**Consultation Response from KC,
Highways Development Management****2024/90058 Penistone Road/, Rowley Lane, Fenay Bridge, Huddersfield, HD8 0JS**

Reserved Matters application, including the considerations of appearance, scale, layout, and landscaping, for the erection of 67 dwellings, pursuant to outline permission 2020/92307 for the erection of residential development (up to 75 units) and the discharge of conditions 7 (include a Written Scheme of Archaeological Investigation (WSI) and Designer's Response), 8 (Foul and Surface Water Drainage Strategy), 9 (flood routing), 10 (mitigatory tree-planting), 11 (cycle parking), 12 (Arboriculture Assessment), 13 (Ecological Design Strategy), 14 (Bar survey), 15 (noise impact assessment)

Date Responded: 28/03/2024**Responding Officer: Ryan Kinder****Responding Ref: K11-11-2**

Project. Penistone Road, Fenay Bridge			
Client. Homes By Honey			
Drawing. Large Refuse Vehicle Swept Path Analysis			
Drawn By:	SD	Date.	25/08/2023
Checked By:	ATM	Scale.	1:500
Drawing No.	AMA/22387/ATR001.1	Paper size.	A3
		Rev.	-

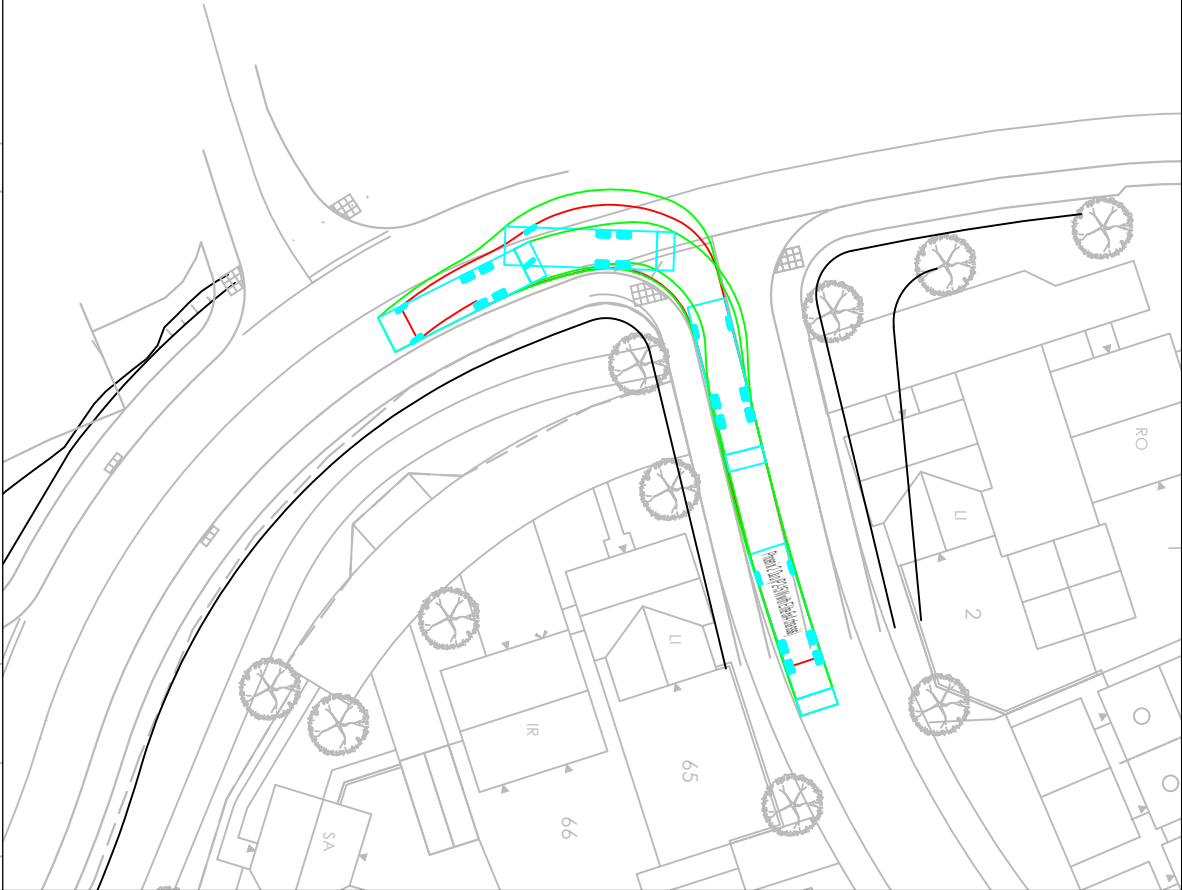
- Swept paths for an 11.85m refuse collection vehicle (current is 11.2m)
- Finished gradients and an appropriate plan indicating long sections on the internal estate roads.
- Appropriate sight lines at internal junctions demonstrated, forward visibility on internal roads demonstrated and achievable within the adopted highway.

Off street parking appears to be provided in accordance with suggested guidance in the Councils SPD – Highway design guide, however the level of visitor parking required for this development should be 19 spaces, which there appears to be a shortfall. If on street parking for visitors is to be utilised, then it is essential that swept paths for refuse vehicles (11.85m) is demonstrated accordingly.
